May 13, 2016

Apartments

667 Congress Street, Portland, Maine

Permit Review Comments Response

1 FLOOR PLAN  
 1/4" = 1'-0"

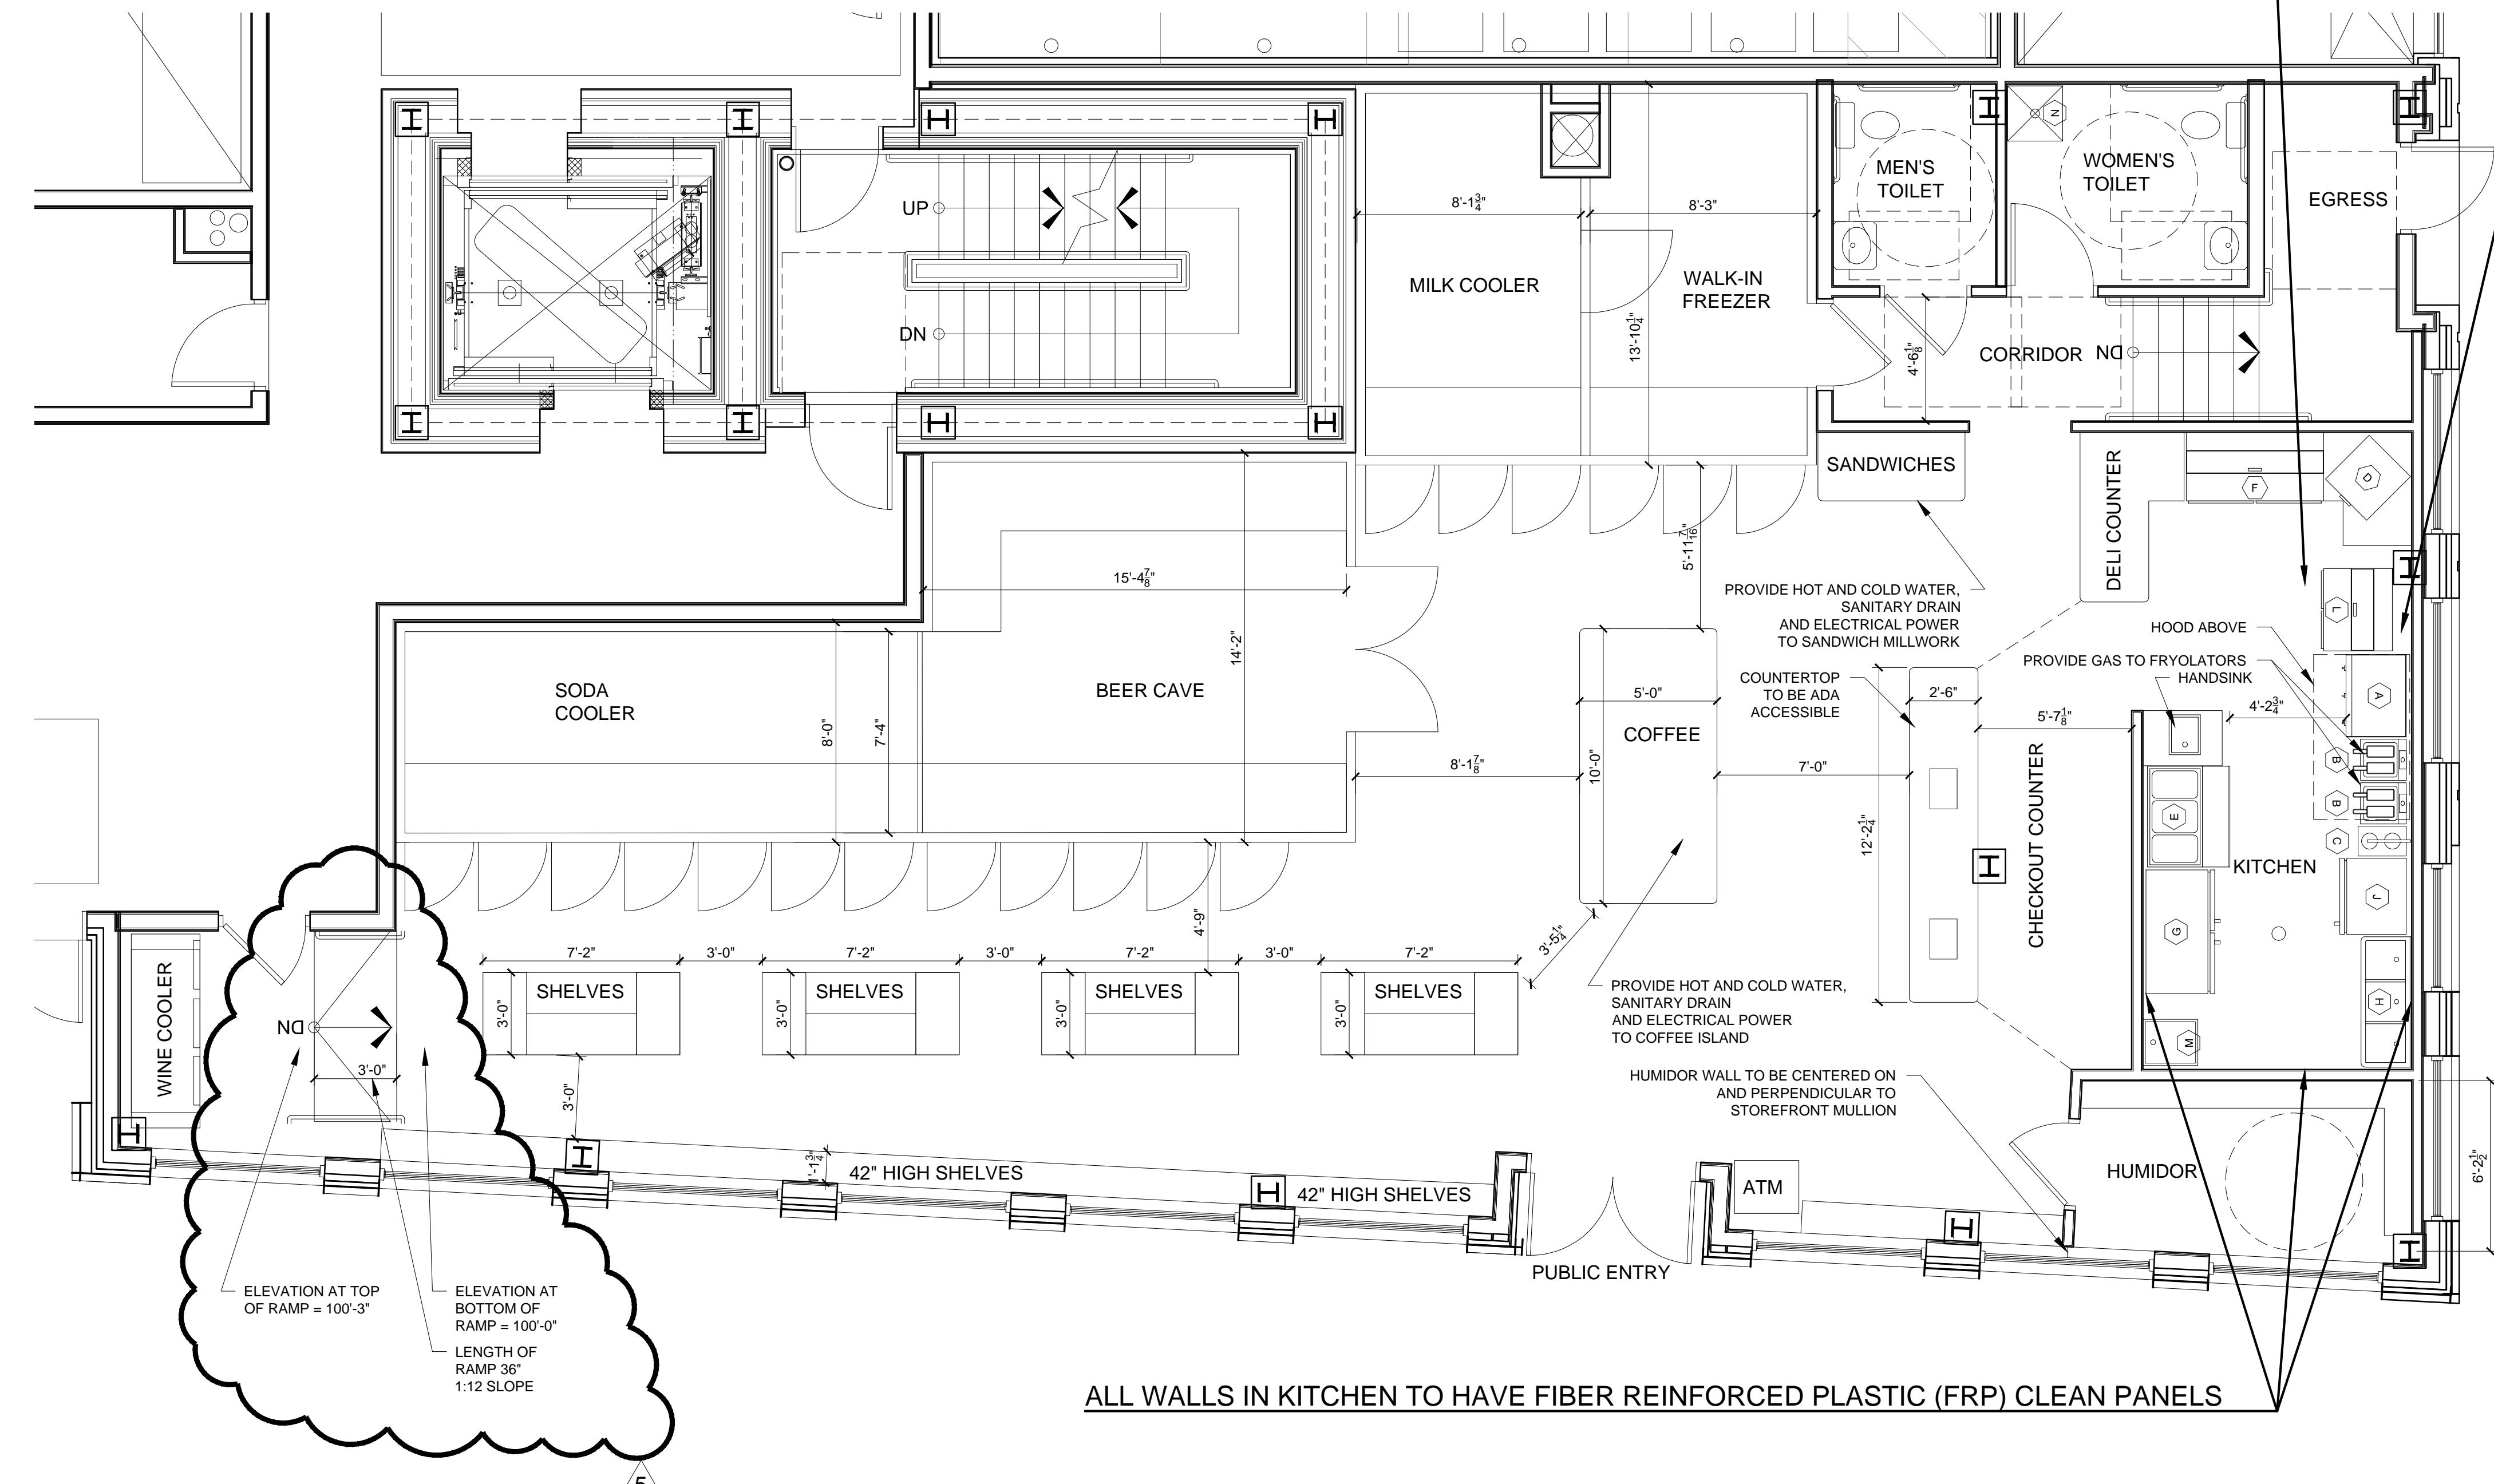
3.) Drawing A1-50 comment: The Women's Toilet room door is required to have a forward approach to the push side of the door of 48" out from the door and 12" to the latch side of the door, we are providing 4'-6-1/2" out from the push side of the door and 1'-5" to the latch side of the door which meets ADA 2010 404.2.4.1 (c).

The Men's Toilet room door is required to have a pull side approach of 4'-6" out from the door and 24" on the latch side of the door, we are providing 4'-6-1/2" out from the door and 6'-0" to the latch side of the door which meets ADA 2010 404.2.4.1 (i)
